# KITTITAS COUNTY FIRE MARSHAL'S OFFICE

December 26, 2014

Re: Schnebly (BL-14-00024)

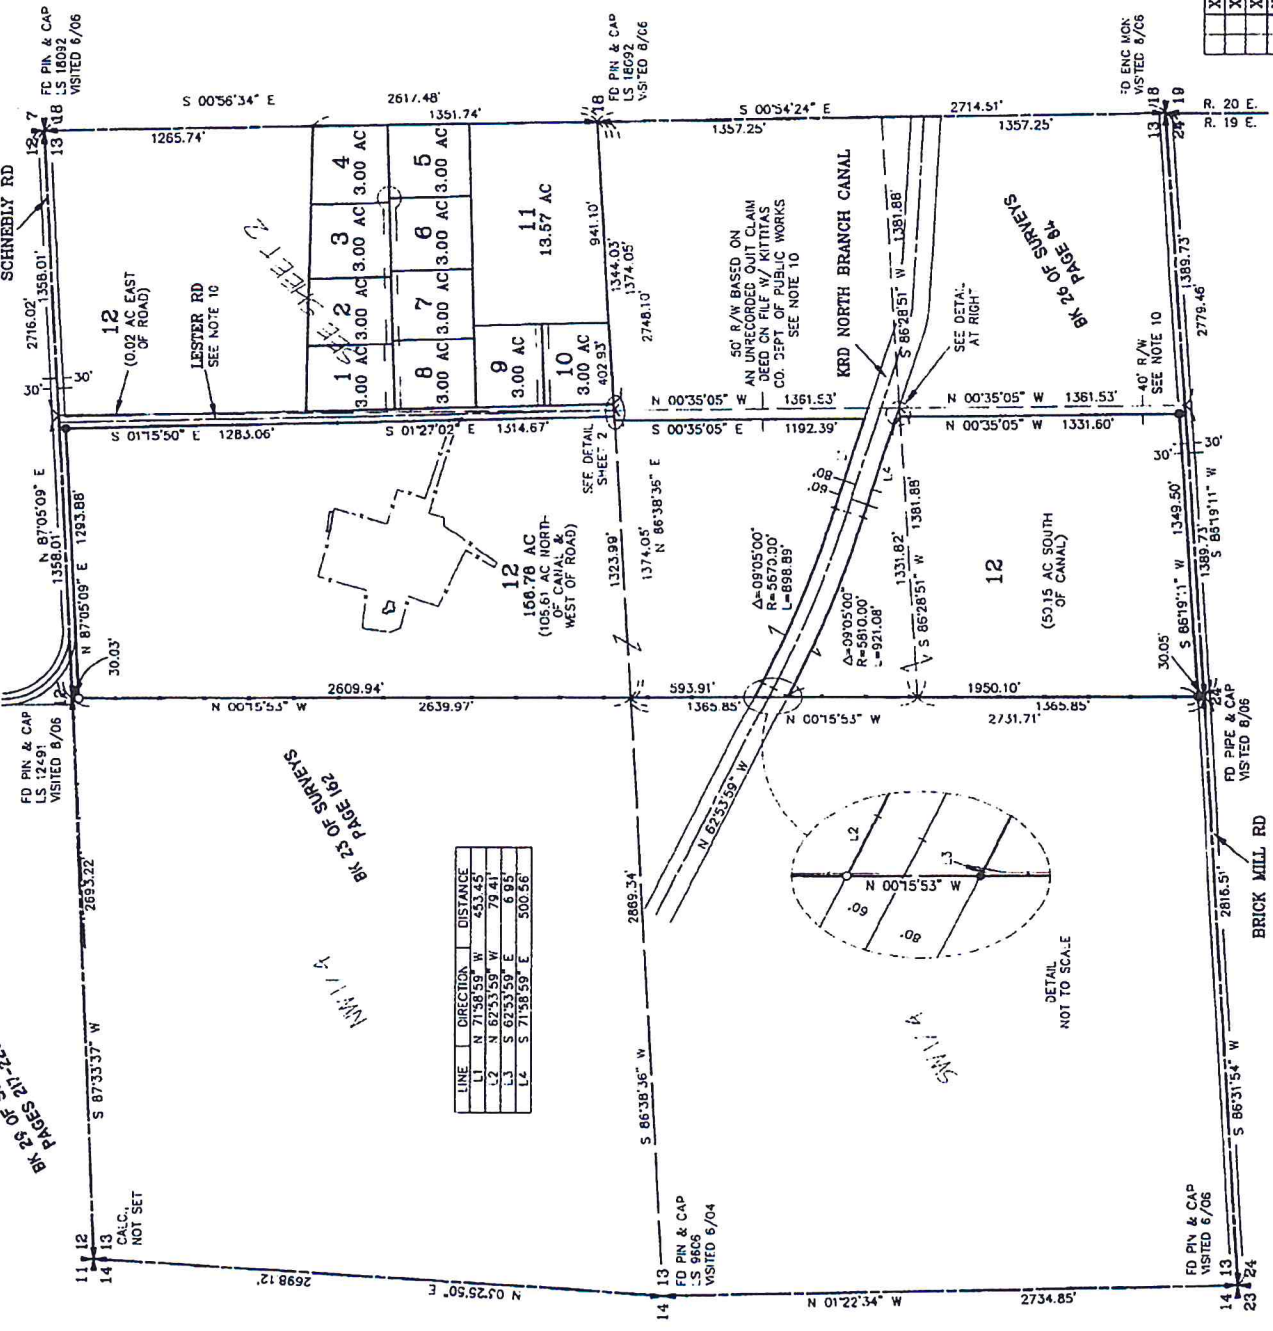
- The driveway(s) for the new property must comply with Kittitas County Code, i.e. any driveway greater in length than 150' shall be no less than 16 feet in width.
- The addresses shall be posted at the front of the property and easily visible from the road to emergency responders.
- Any new structures or substantial development to existing structures will require a WUI permit.
- All future development must comply with the International Fire Code.
